Appeal Decision

Appeal Ref: APP/R5510/X/25/3366174

36 Summerhouse Lane, West Drayton UB7 0BG

EX01

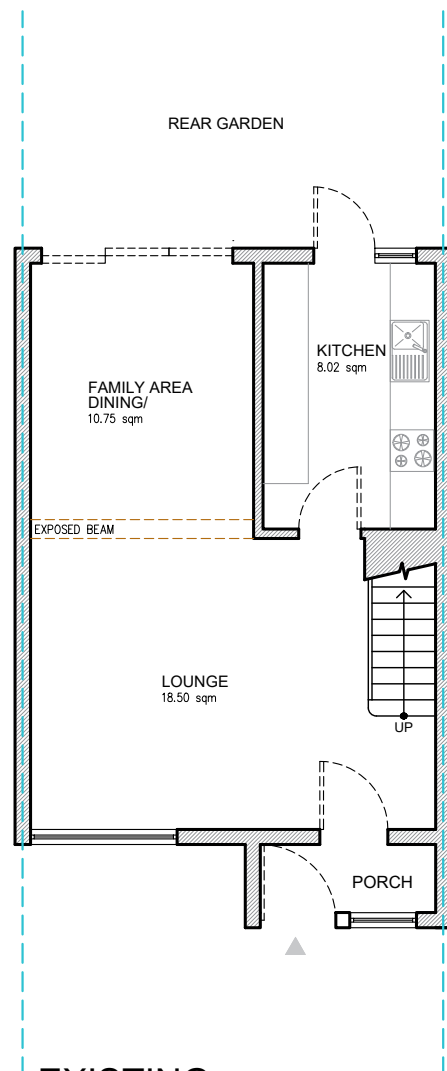
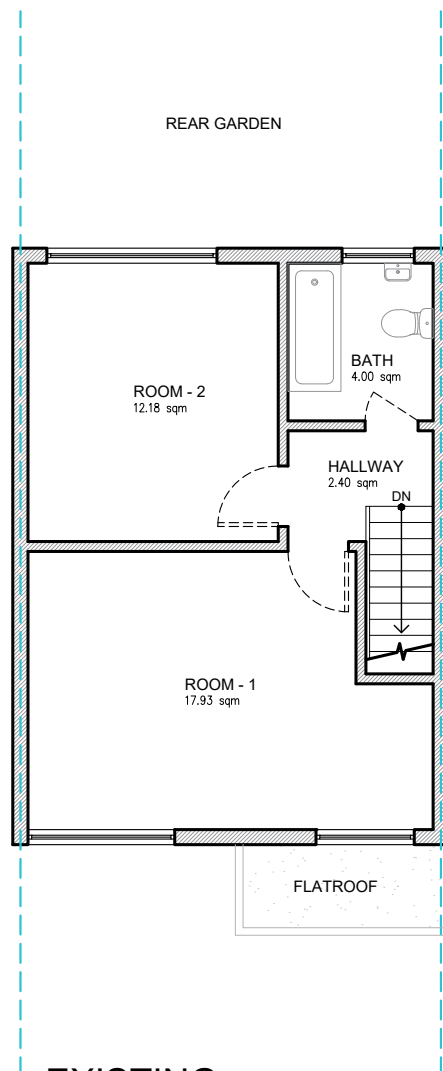
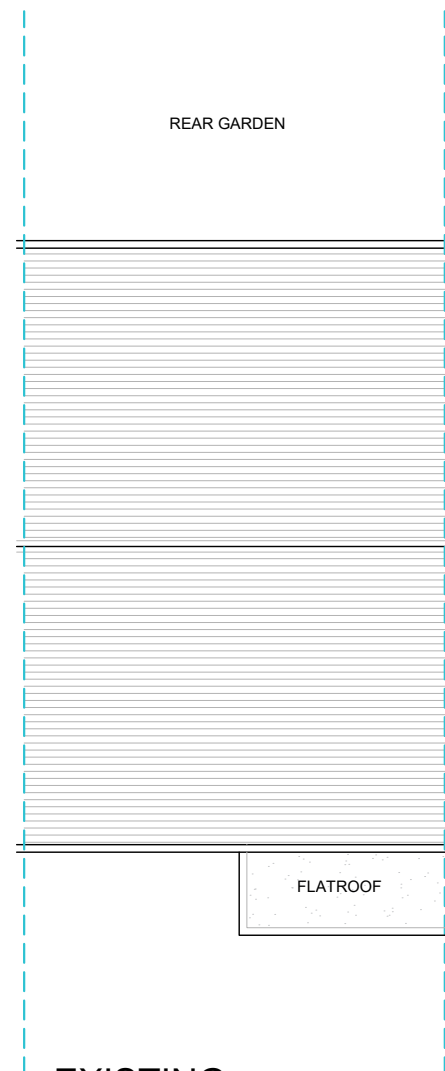
7. The appellant assessed the external ground area of the porch as not exceeding the 3m² limit in Class D, at paragraph D.1(b). This conclusion seems to have been arrived at by excluding the ground area of the existing front porch, which was probably erected contemporaneously with the dwelling, from the total ground area of the proposed porch.

8. Even so, the drawings supplied indicate that the existing porch would be substantially demolished prior to erecting the proposed porch. The reference in the application description to creating a front porch also suggests that the existing porch would be demolished. The ground area measurement for the purposes of paragraph D.1(b) applies to the totality of the proposed porch; nothing in Class D provides that the ground area of the porch being demolished should be taken into account. Moreover, since the demolition works would include removing the existing external door, the door which leads to the hallway would be the 'external door' for the purposes of Class D. Consequently, I share the Council's view concerning the total floor area of the porch, which at around 5.83m² measured externally would breach the limitation in paragraph D.1(b).

NORTH-EAST ELEVATION (FRONT VIEW)

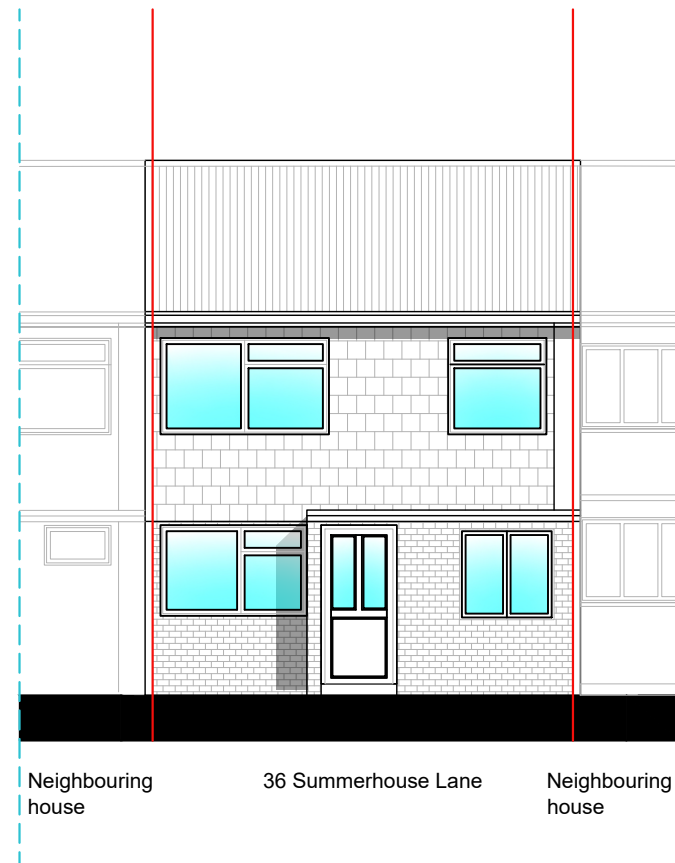
9. The porch would not breach the 3m height limit in sub-paragraph (c), it would be further than 2m from the highway complying with sub-paragraph (d) and sub-paragraph (a) is not relevant in this instance. Even so, development which breaches any of the relevant limitations and conditions of a specific Class within one of the Parts of Schedule 2 is not granted planning permission by the GPDO.
